# CITY OF ALBUQUERQUE

**Re: 4800 San Mateo  
4800 San Mateo Blvd NE  
30-Day Temporary Certificate of Occupancy  
Transportation Development Final Inspection  
Engineer's/Architect's Stamp dated 8-22-18 (F18D049A)  
Certification dated 6-18-19**

1 Site plan Scale: 1/8" = 1'-0"

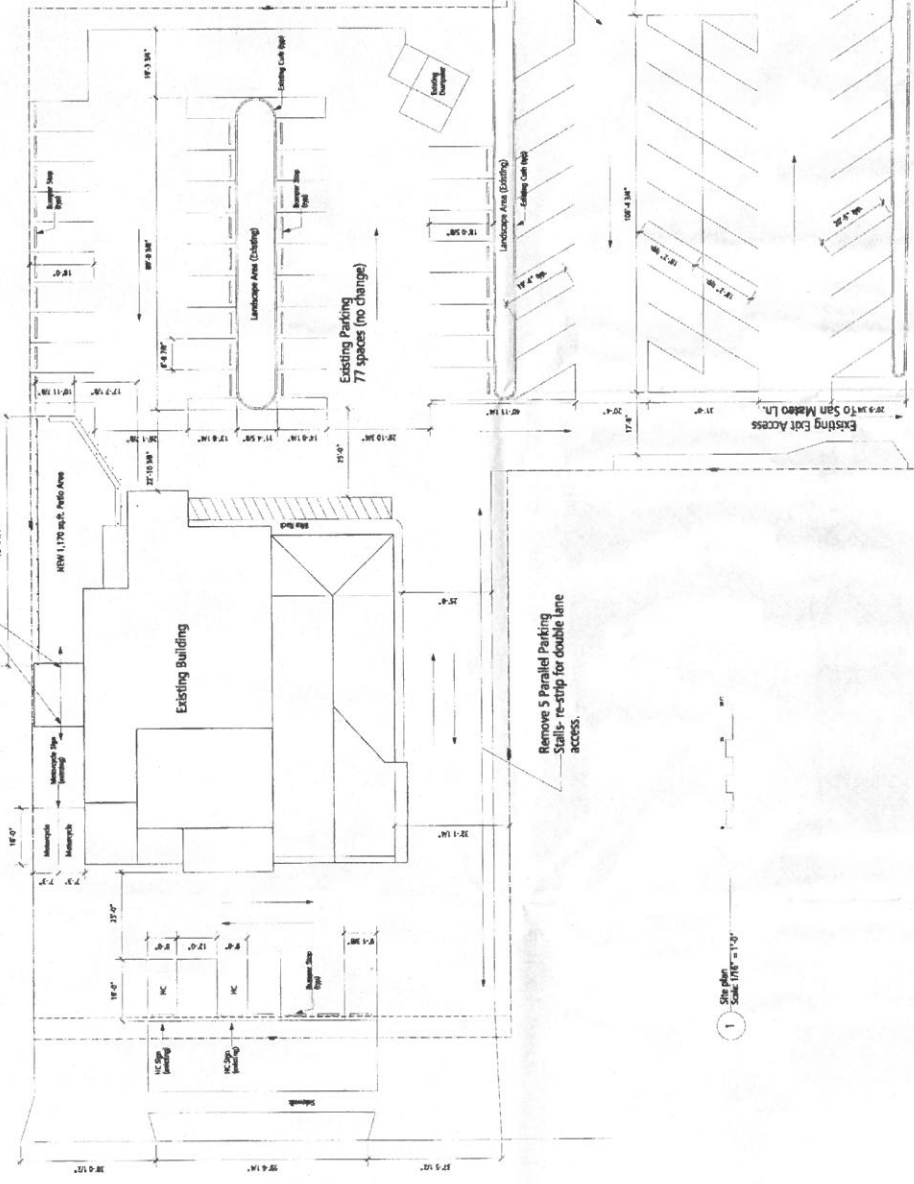
1. Please add motorcycle cycle parking signs.
2. Please add bike rack.
3. The ADA accessible parking sign must have the required language per 66-7-352.4C NMSA 1978 "**Violators Are Subject to a Fine and/or Towing.**".
4. Send pics of corrections to [epgomez@cabq.gov](mailto:epgomez@cabq.gov) for release of final CO.
